**Reference:** AW/14/22/T

**Location:** 96 Barrack Lane, Aldwick, PO21 4DG

**Proposal:** 1no. *macrocarpa* tree - Reduce all side limbs by 3m to leave 5m and reduce height from 16m to leave 13m

REF 1

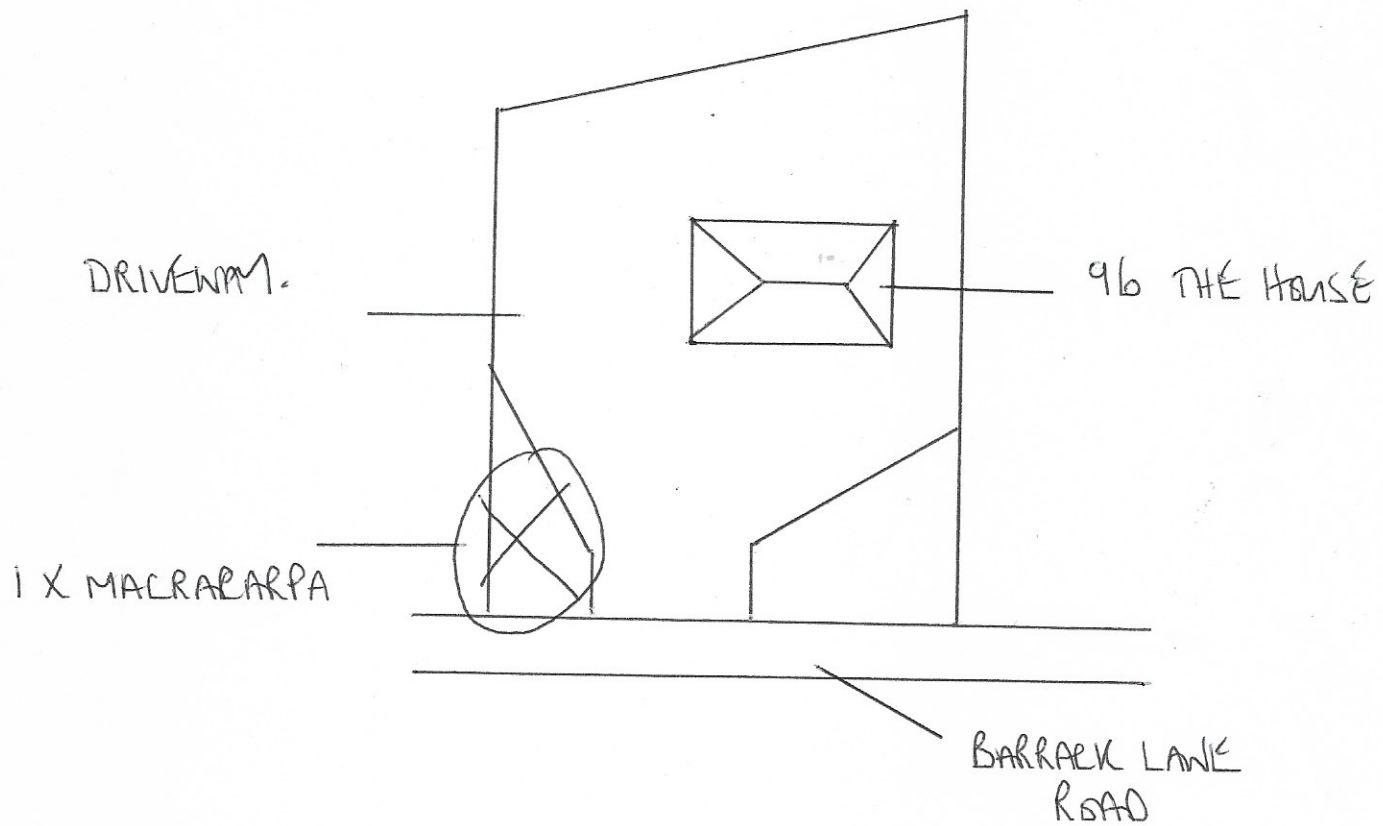
- The proposal involves a >60% reduction in crown volume and would leave very little live foliage from which the tree could sustain itself. Such an operation far exceeds the requirements of British Standard 3998:2010 Tree work – Recommendations.
- No arboricultural justification has been offered in support of crown reduction pruning to any extent.

- I recommend **REFUSAL** for this application.
